CITY OF ALBUQUERQUE

August 24, 2018

Re: McDonald's
5324 4th St NW Albuquerque, NM
Traffic Circulation Layout
Engineer's/Architect's Stamp ??-??-?? (F14D039)

SP-2

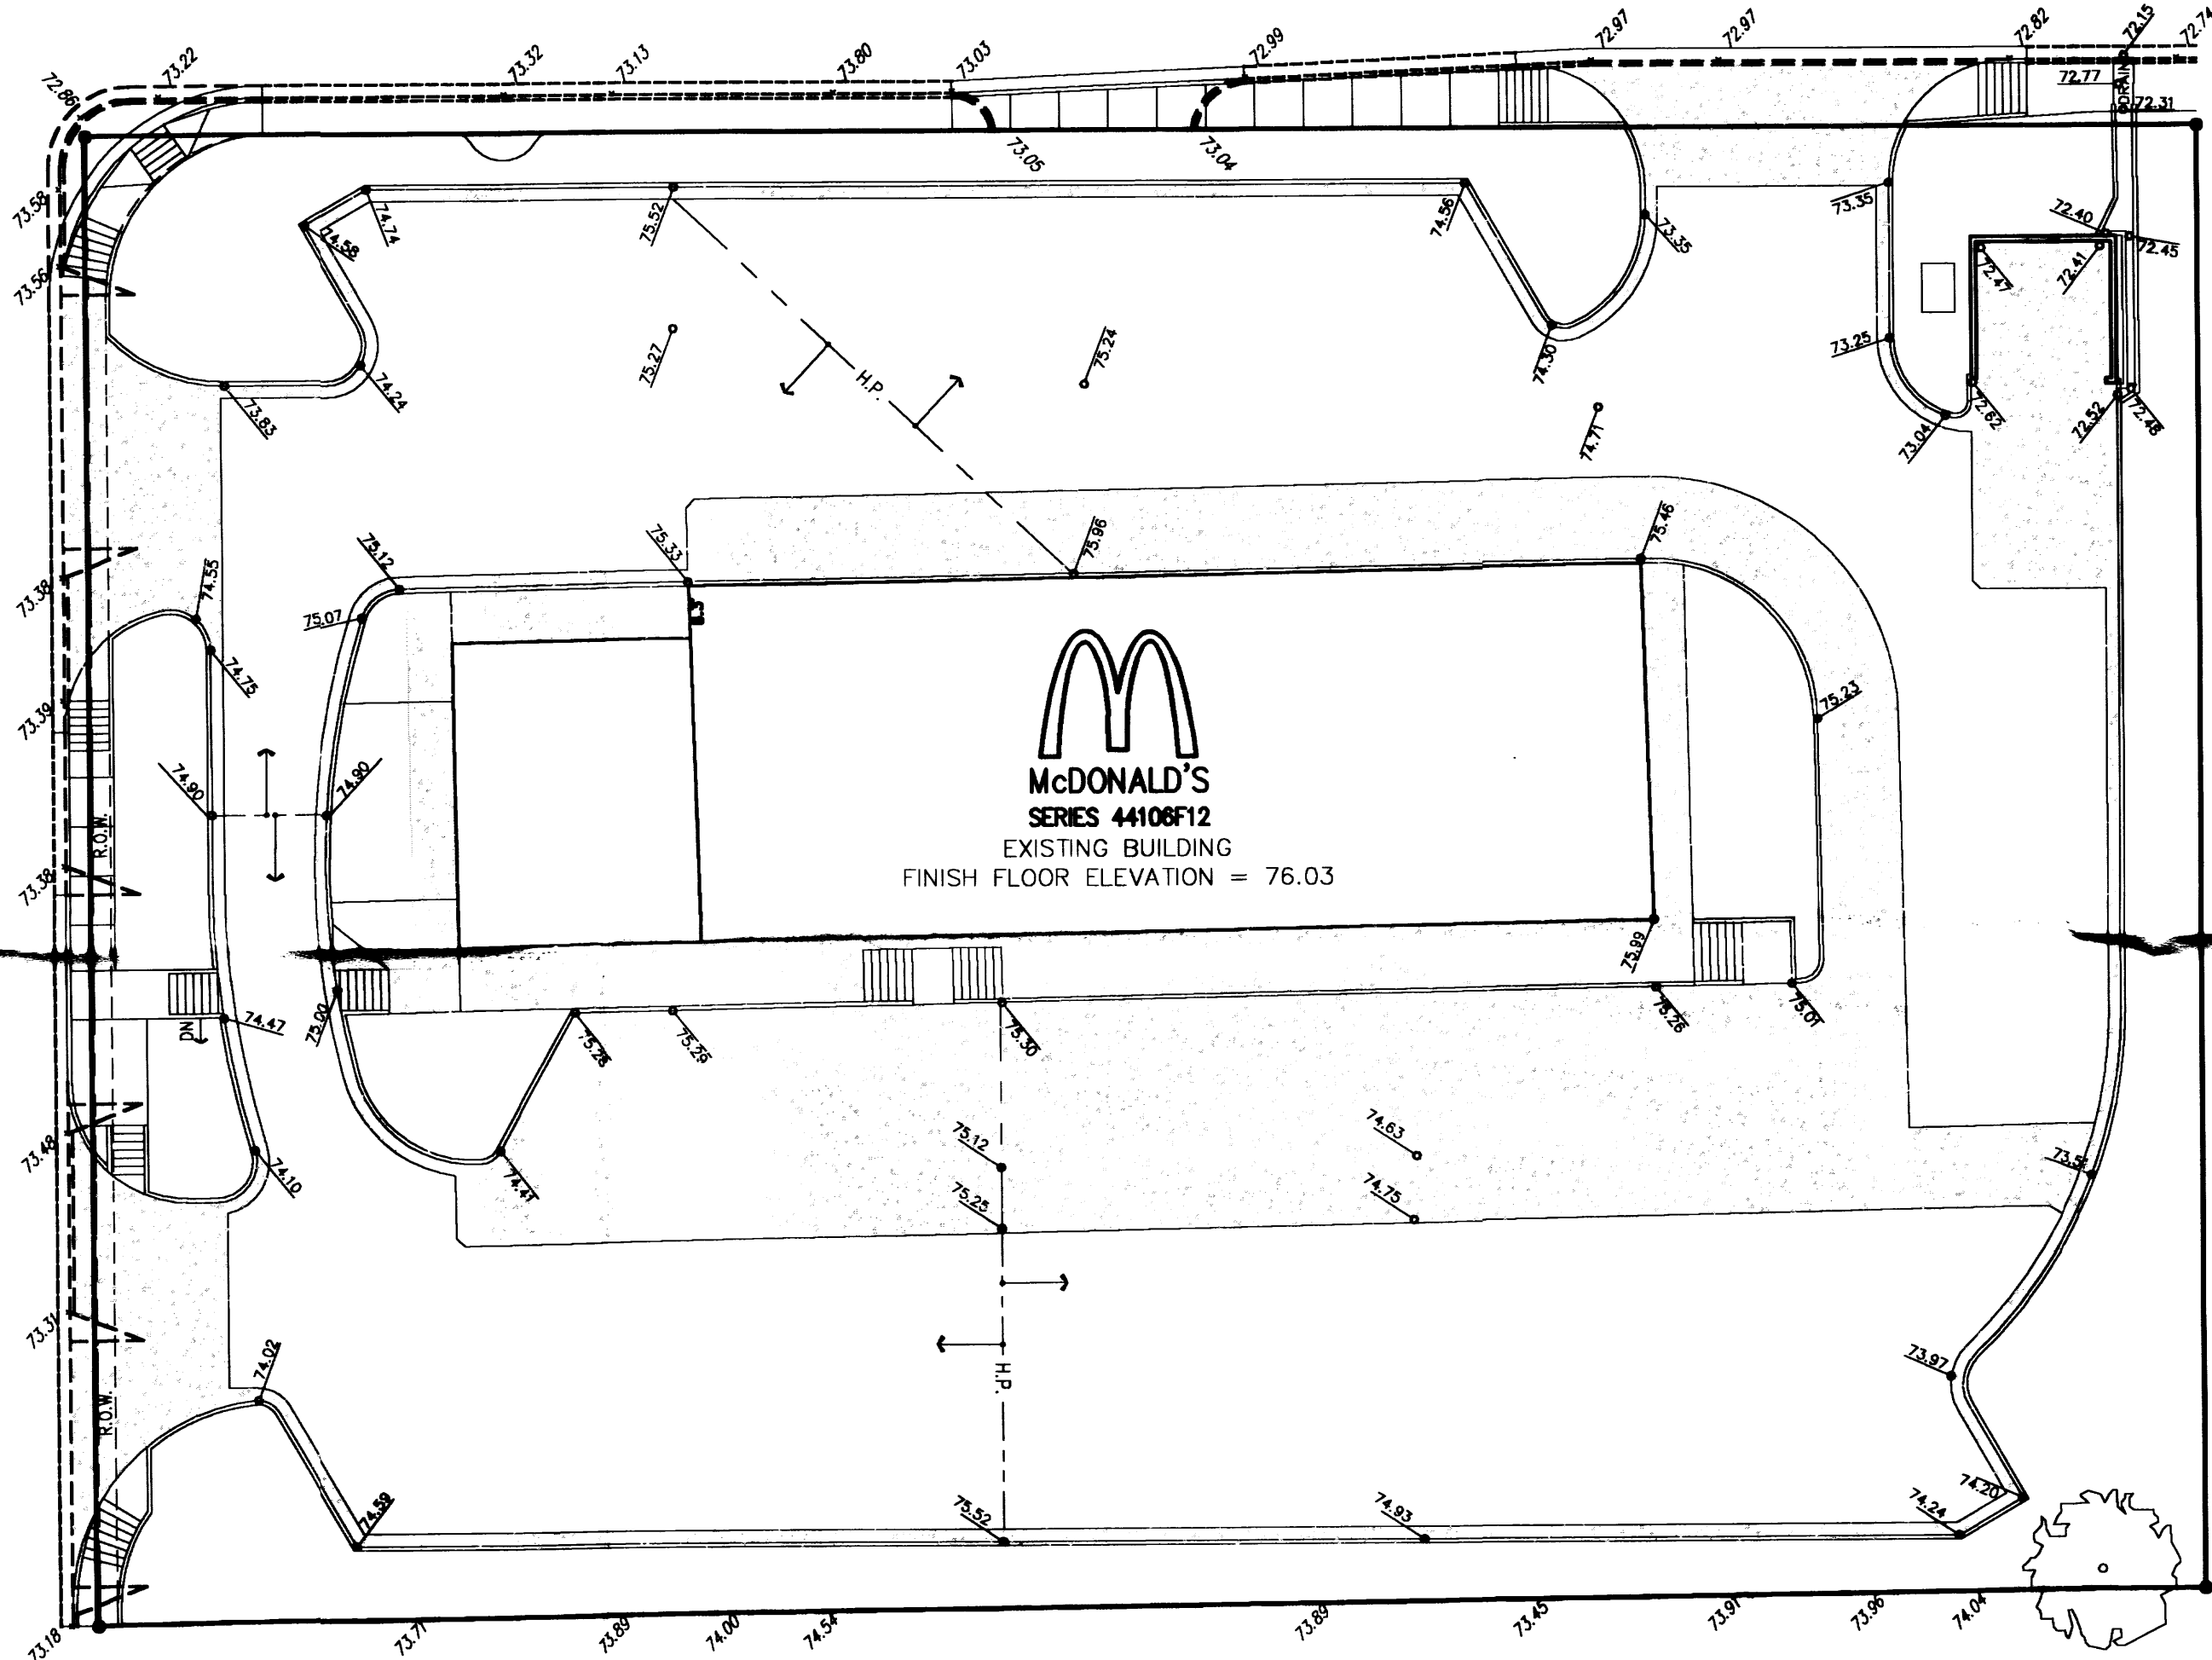
1. Please show a vicinity map showing the location of the development in relation to streets and well-known landmarks.
2. The traffic circulation layout must be stamped, signed, and dated by an engineer or architect licensed in the state of New Mexico.

3. Please list the width and length for all existing and proposed parking spaces. Some dimensions are not shown.
4. The handicap accessible spaces must be a minimum of 8.5 ft. in width.

5. The ADA access aisles shall have the words **"NO PARKING"** in capital letters, each of which shall be at least one foot high and at least two inches wide, placed at the rear of the parking space so as to be close to where an adjacent vehicle's rear tire would be placed. (66-1-4.1.B NMSA 1978)

6. Show all drive aisle widths and radii. Some dimensions are not shown.
7. The minimum drive through lane width is 12 feet with a 25-foot minimum radius (inside edge) for all turns. (A 15 foot radius can be used with an increase in lane width to 14 feet). Please dimension all lane widths and radii.
